EP/141/14/HH – Little Thatches, 34 Tamarisk Way

We write further to our letters dated 18 and 31 July under reference EP/97/14/HH and have examined the revised plans submitted for planning approval.

Ground Floor Plan
scale 1:100

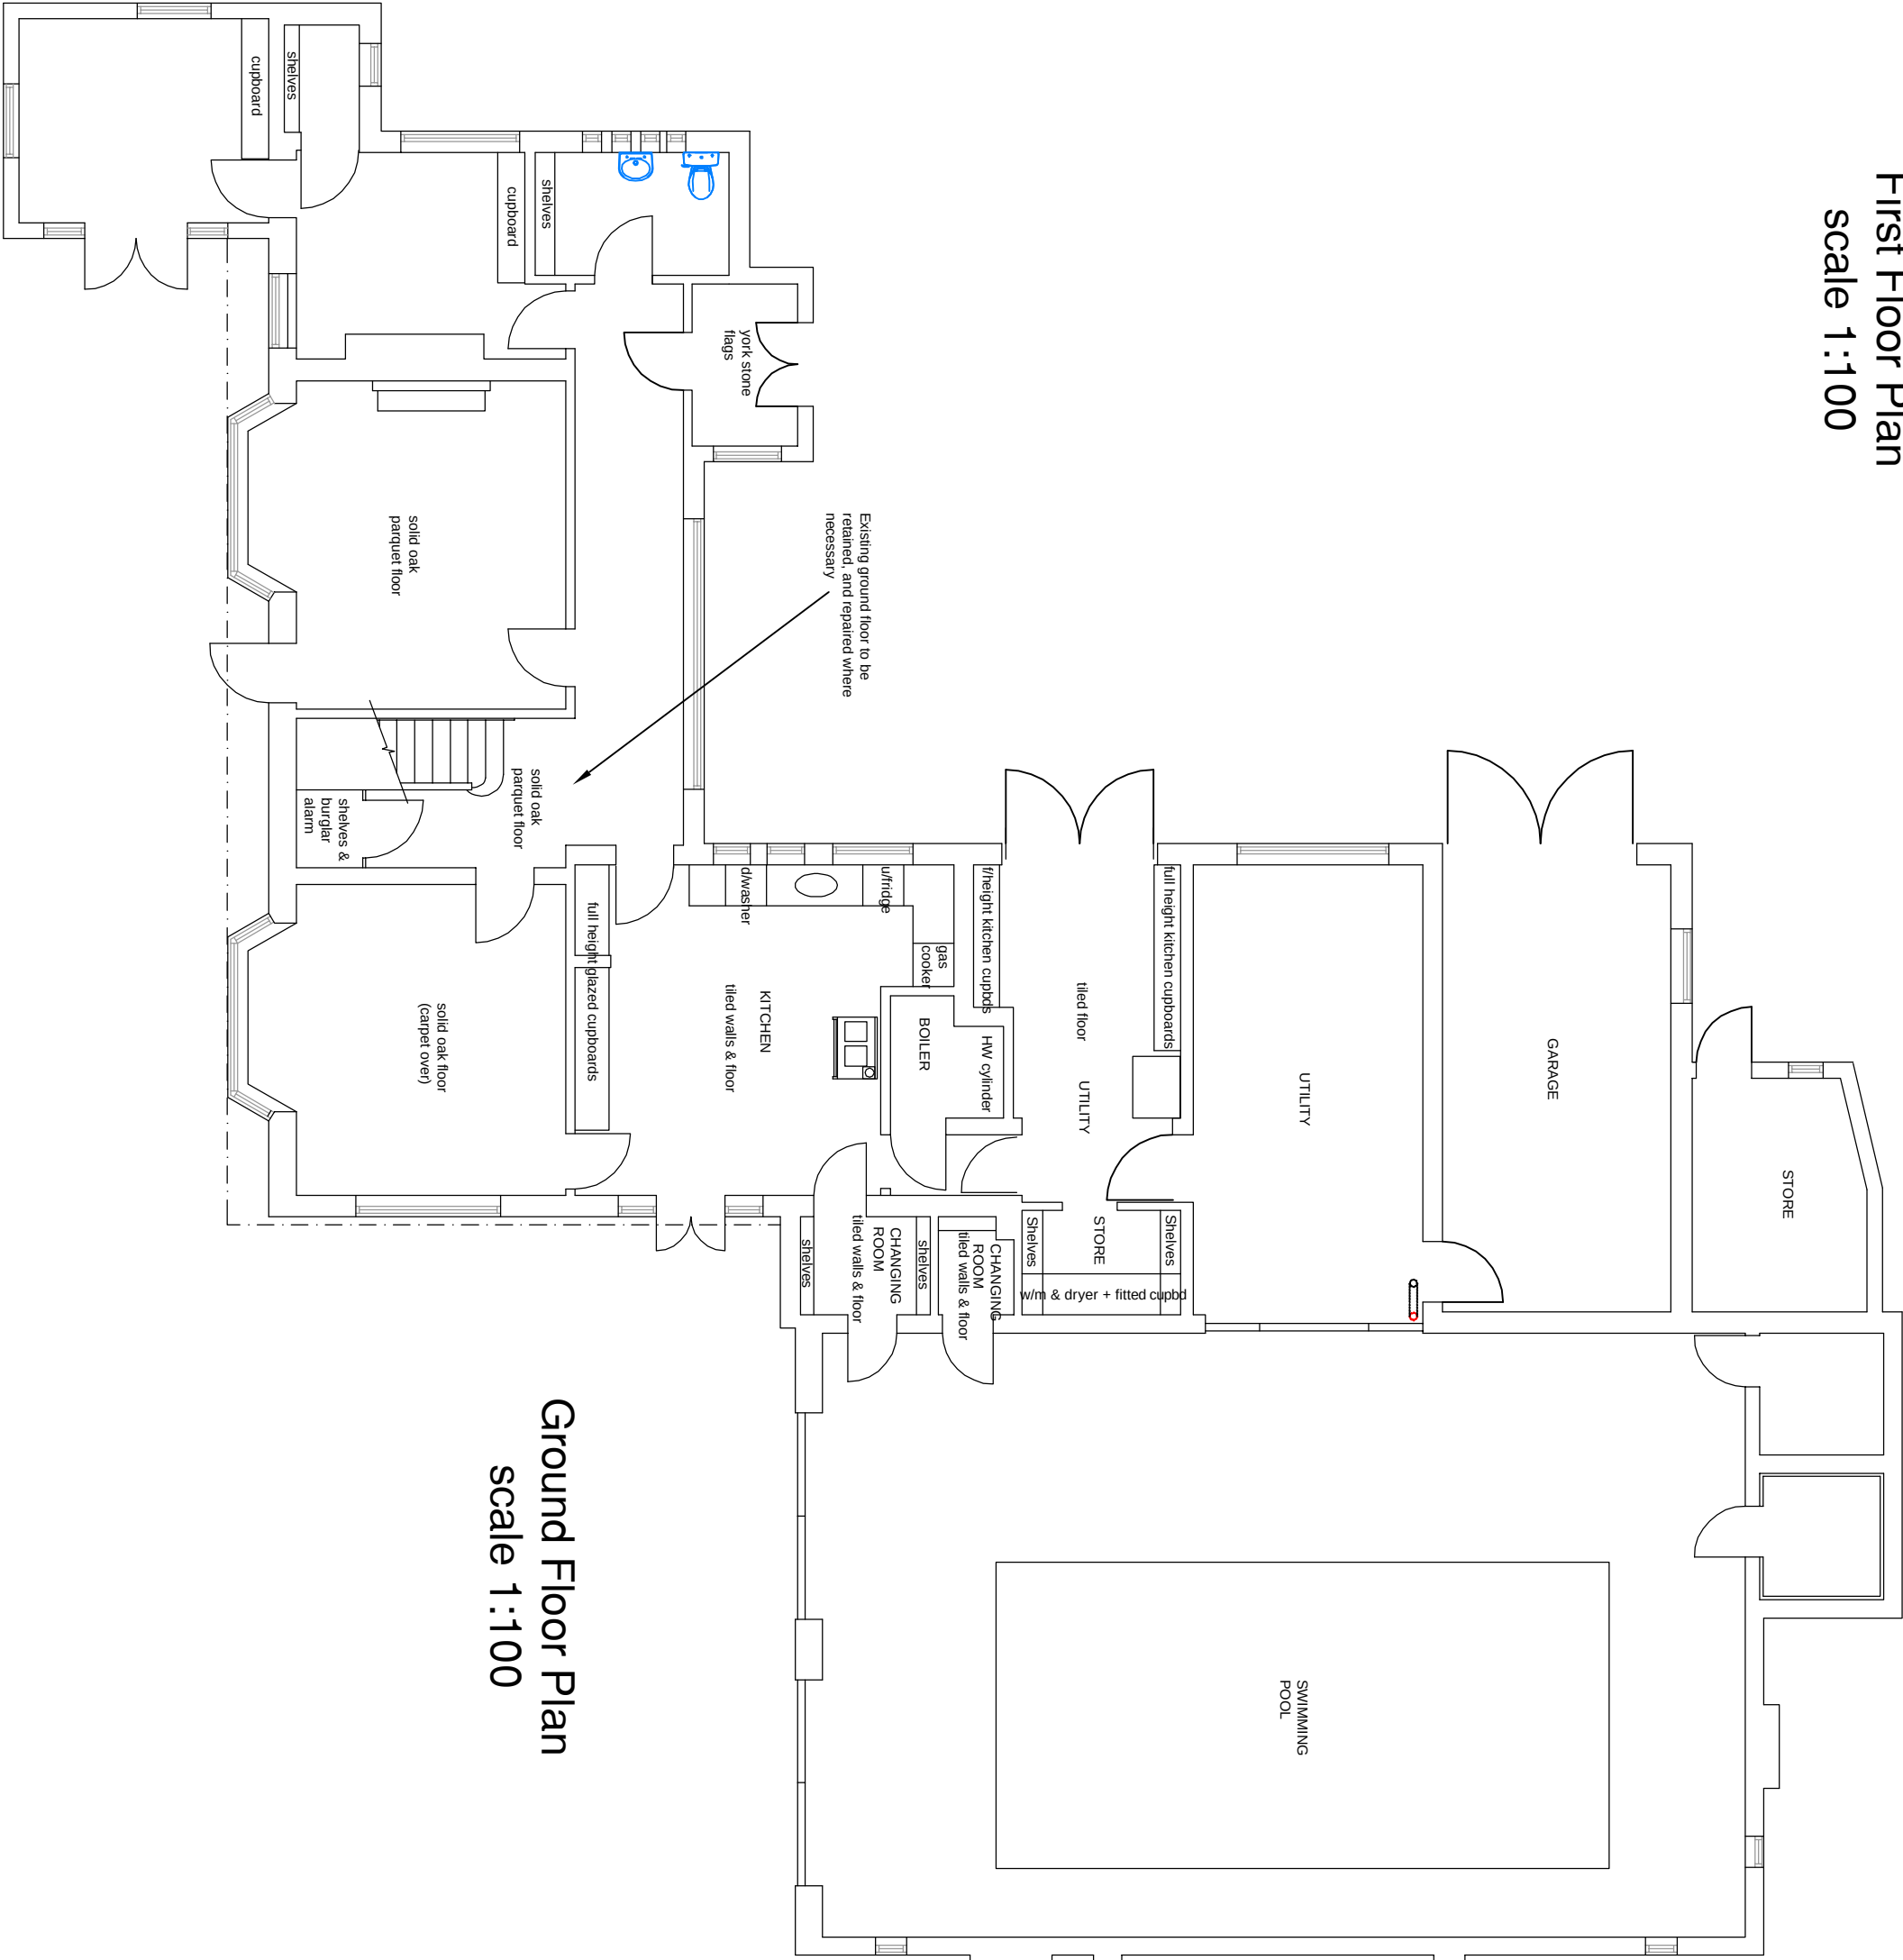
Our concern has always been that parts of Little Thatches (for example the garage and pool) run within inches of our rear boundary fence and we consider that the opportunity should have been taken to move the whole property some distance south, particularly as there is a large amount of vacant ground between the property and Tamarisk Way. This would give us light and privacy which we do not at present enjoy.
